# ENG-PUDSP22001-R1-PDR.pdf Markup Summary

PUDSP221

DEVELOPED CONDITIONS  
HILLSIDE AT LORSON RANCH  
X

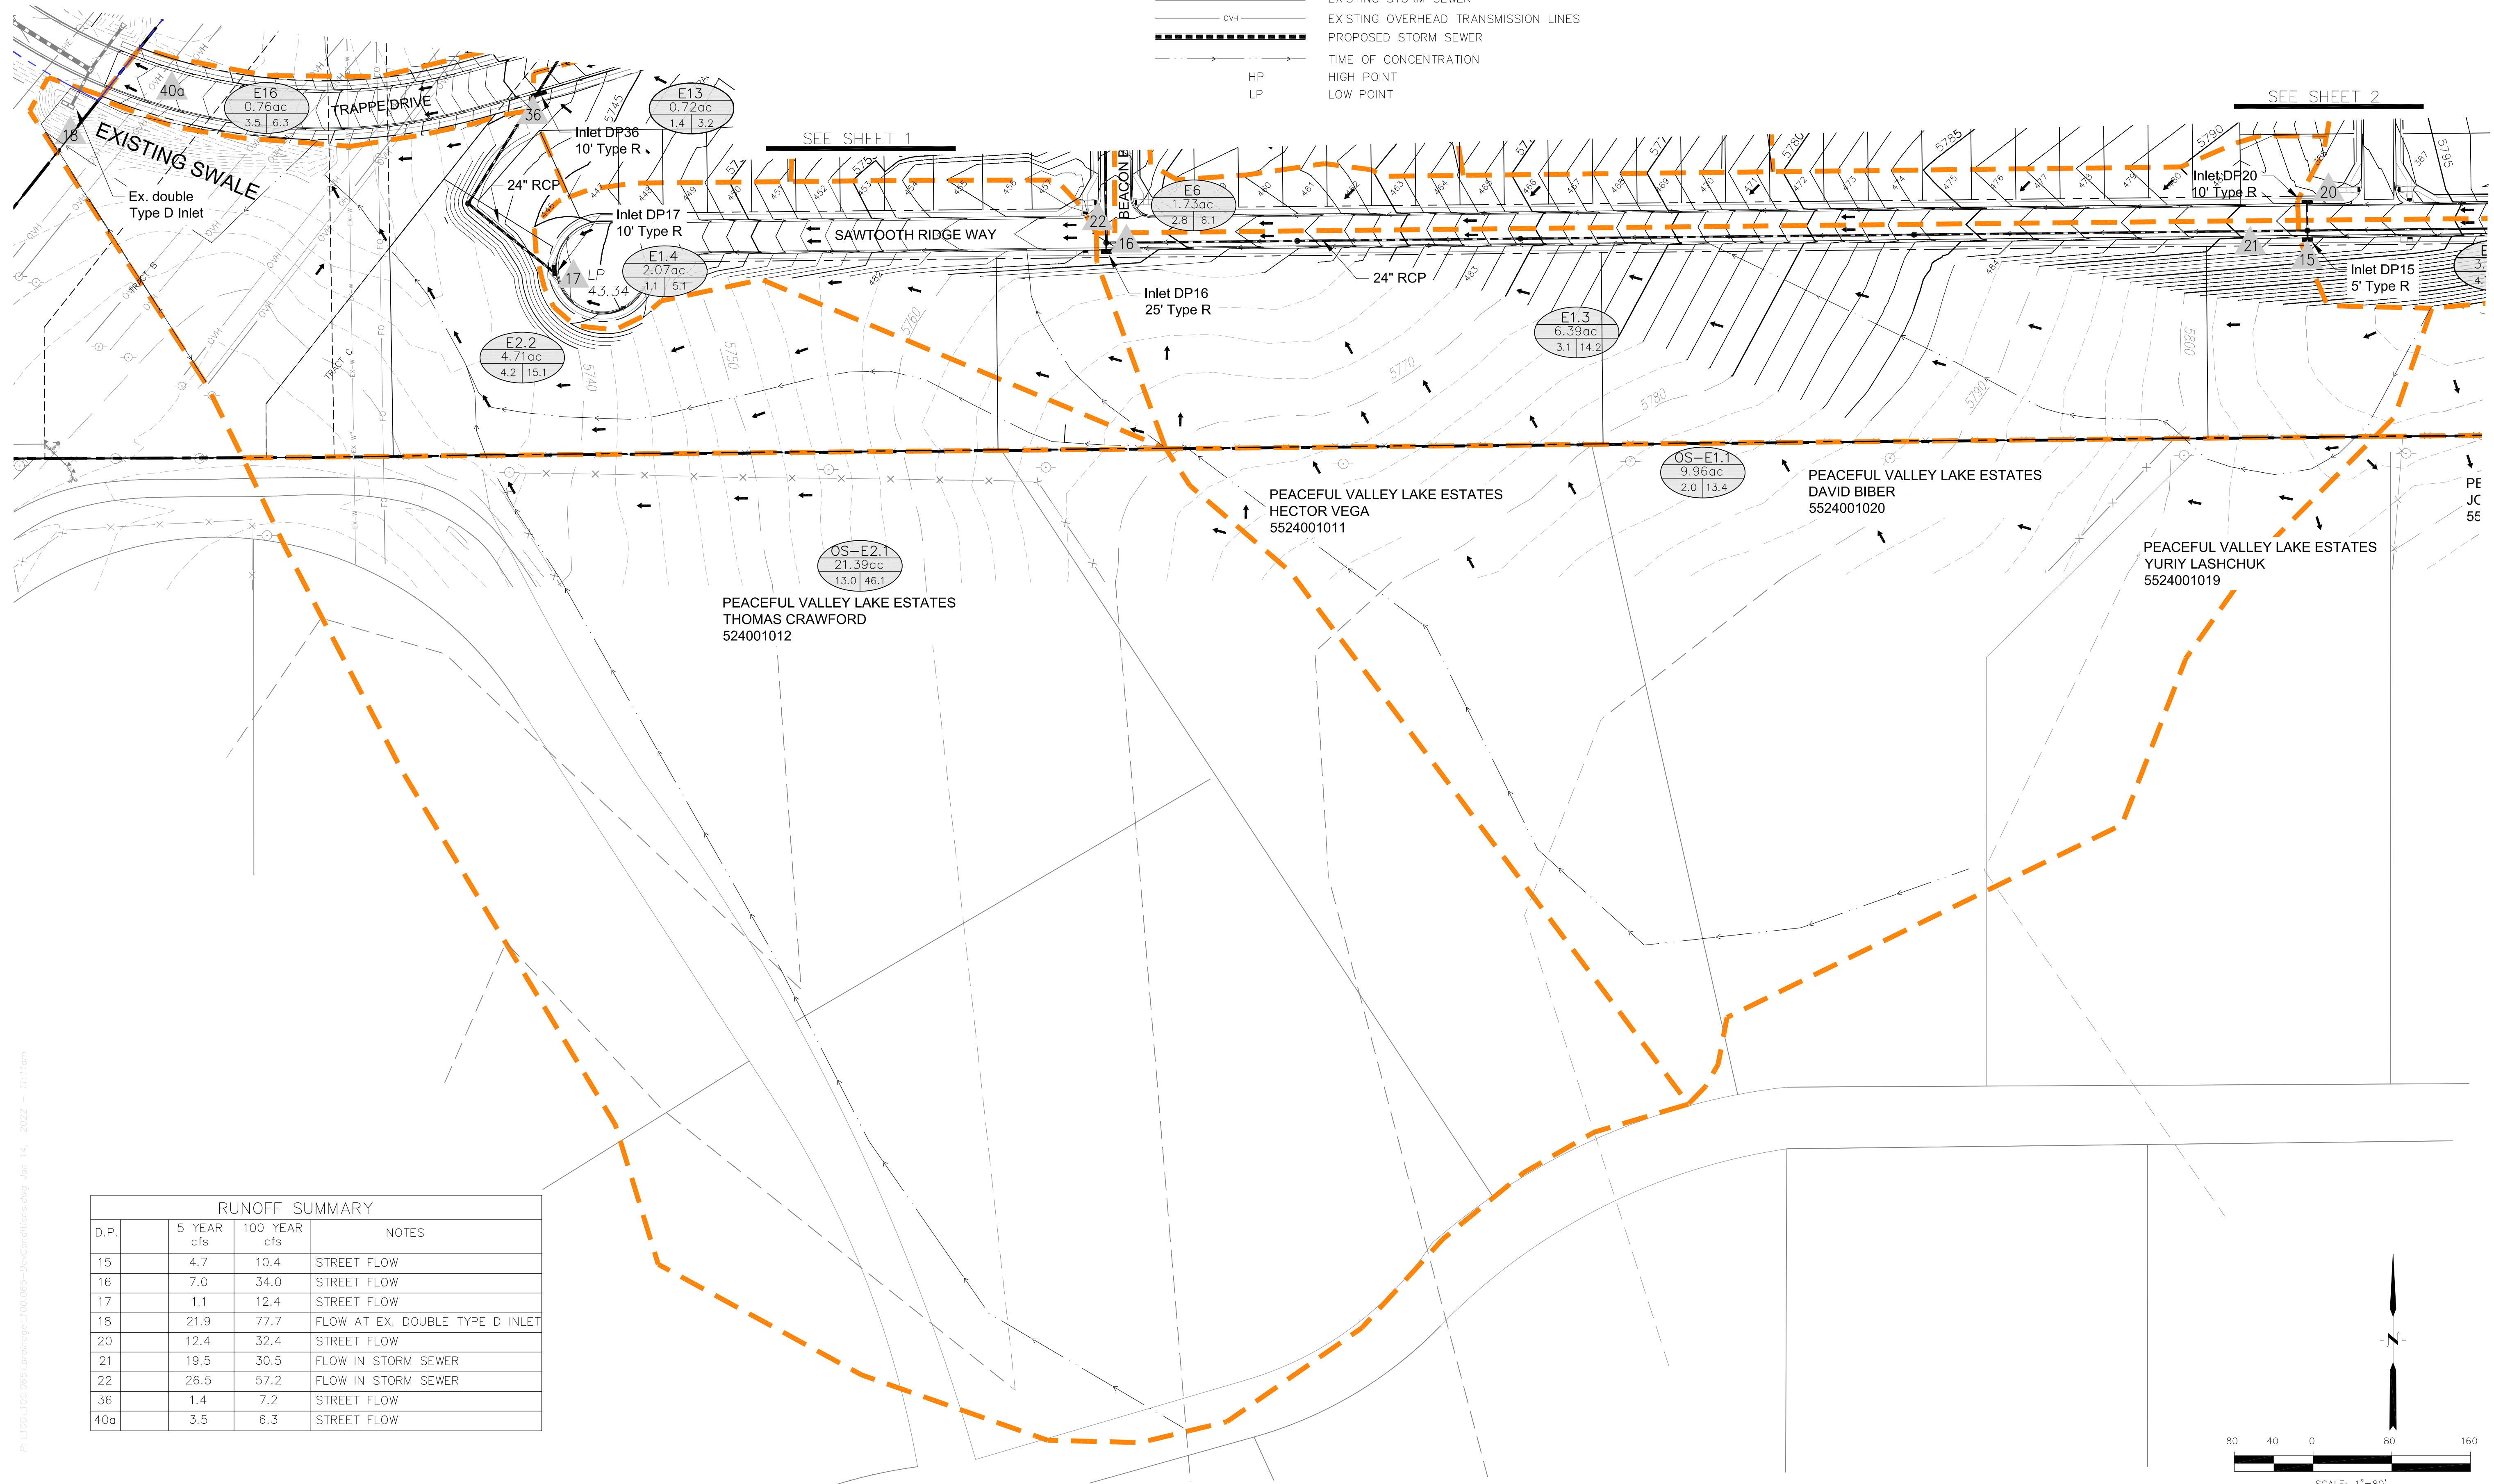
Please hatch the required 50'

Show maintenance access to PBMPs

Show maintenance access to PBMPs

May not be needed if lots are limited to <10% imperviousness. If it is provided, hatch the area.

Recommend directing emergency overflow to the southeast, maybe also provide a berm/swale to get overflow to the spreader area
